From: Anita Gardner
Sent: 10 May 2018 08:21
To: Karen Parsons
Subject: FW: FG/48/18/DOC Onslow Caravan Park, Ferring

The following comments have been received from the Environmental Health Officer re discharge of Condition 6 - Construction Management Plan.

The Drainage Engineer has stated relating to Condition 4 Drainage:

DRAINAGE PLAN - PLANNING
CONDITION 4

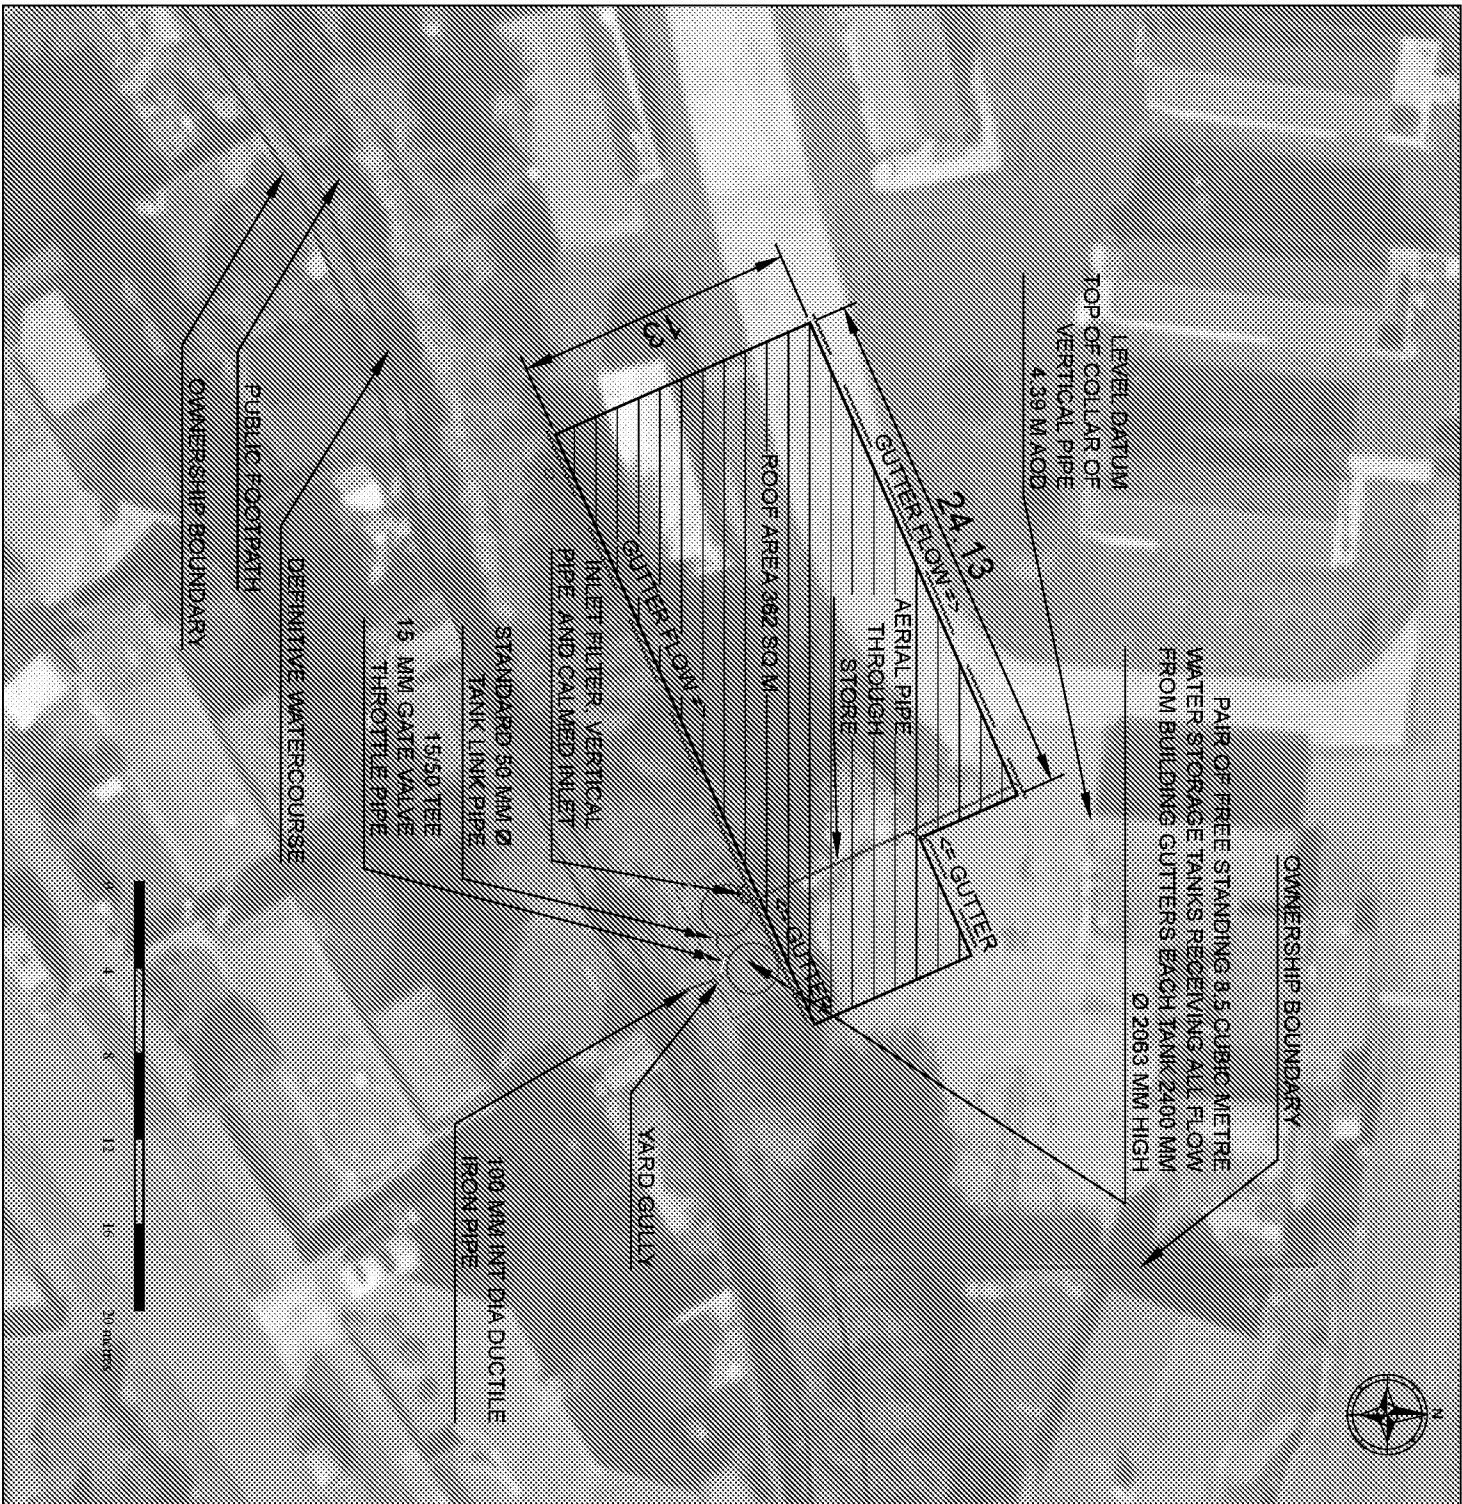
- It is noted that only a 20% allowance for climate change has been included in the design of the surface water drainage system. This needs to be increased to 30% in line with the condition applied.
 - Storm durations from and including 15 minutes need to be used.
 - The restriction size of 20mm is of concern regarding the possibility of blockage. It is recommended that a mesh or similar is installed within each tank at the face of the outlet.
 - It is currently proposed that the outlet to the existing ditch will be formed by a paving slab. This is not acceptable, we require a formal headwall to be formed using concrete bags or brickwork. With full construction detail drawings to be supplied and approved by us.
 - Full construction details will be required including the gully/headwall, any manholes, and silt traps.
- I would therefore appreciate receipt.
